From: David Barnes <[REDACTED]>
Sent: 05 September 2019 13:55
To: Simon Davis <Simon.Davis@arun.gov.uk>
Subject: Fwd: Y/1/17/OUT . New Planning Application No Y/63/19/RES

1. There is now more housing directly overlooking and closer to the listed properties (Bonhams Farm being one) than with the previous agreed plan (plots 36 - 41). The intention was always to leave an apron around these important houses

Figure 3 – Open Space Landscape Strategy: Terra Firma 2019 (with annotations)

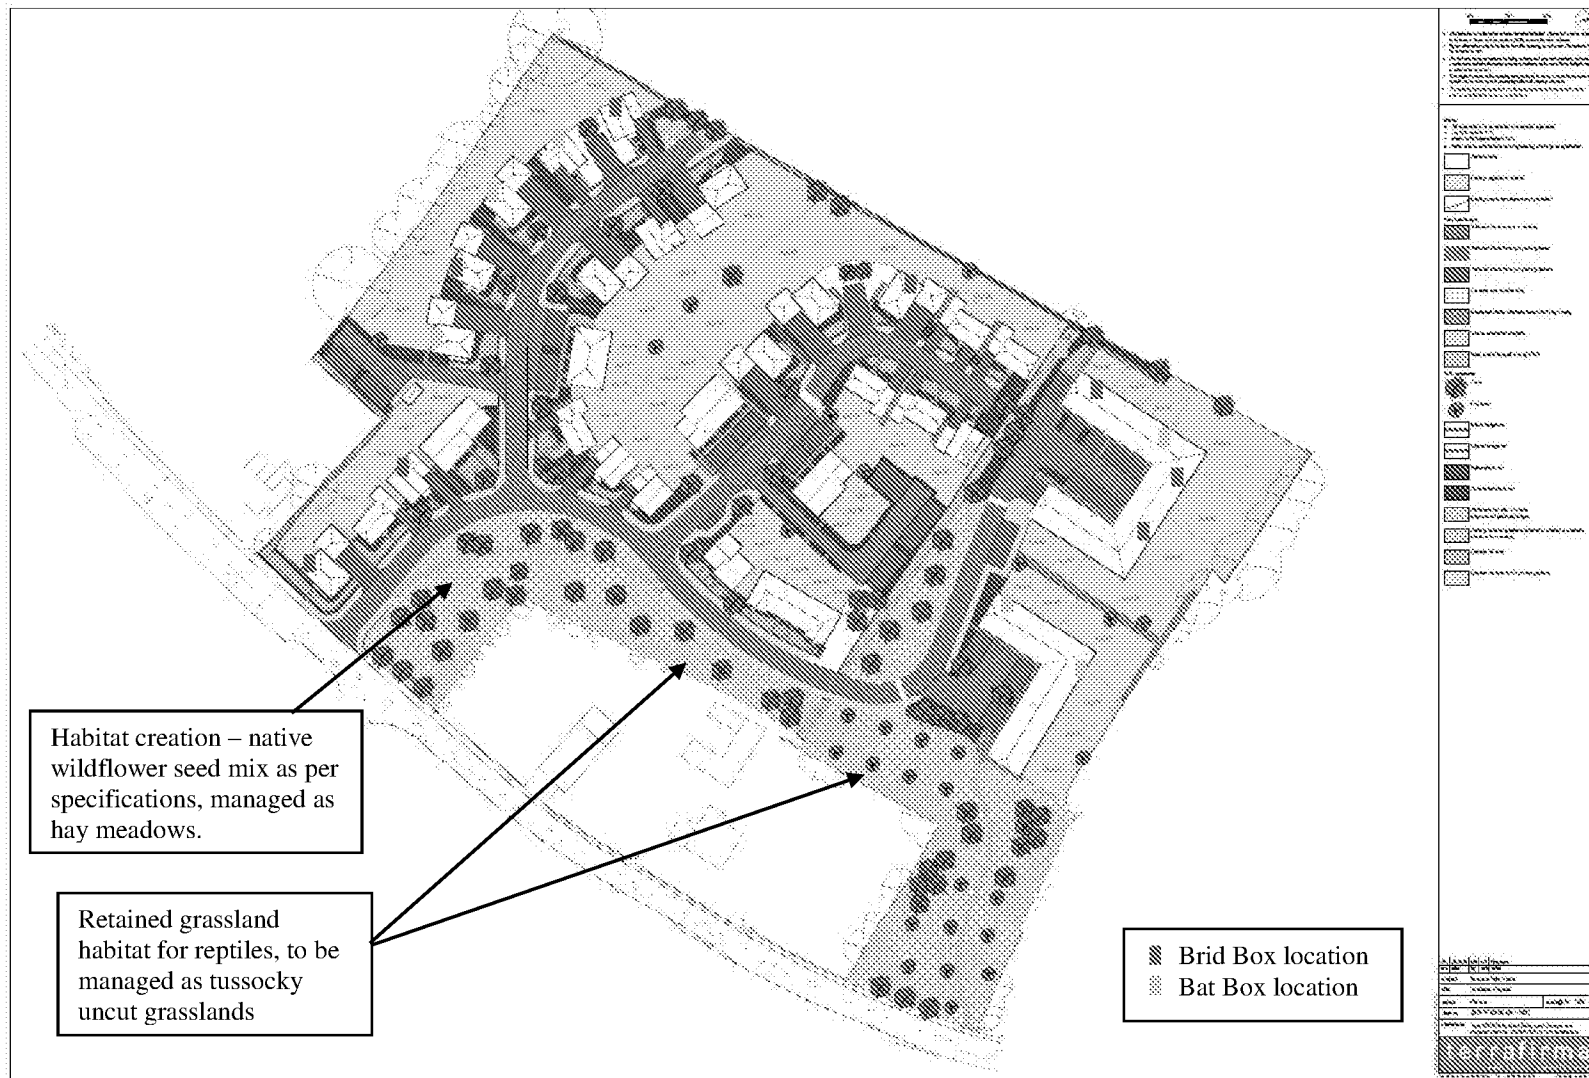
3. The proposed new layout means there will be parking in front of these houses, closer to the boundary than before
4. There appear to be a lot less trees and landscaping in your 'buffer zone' the other side on the north of the boundary.

5. The landscaping proposed is grassland and wild flowers, and not trees and shrubs which would be more of a visible & noise screen
6. Without a proper landscaping screen light glare from the streetlights on the new road is more likely (although no details of lighting has been included in the plans).
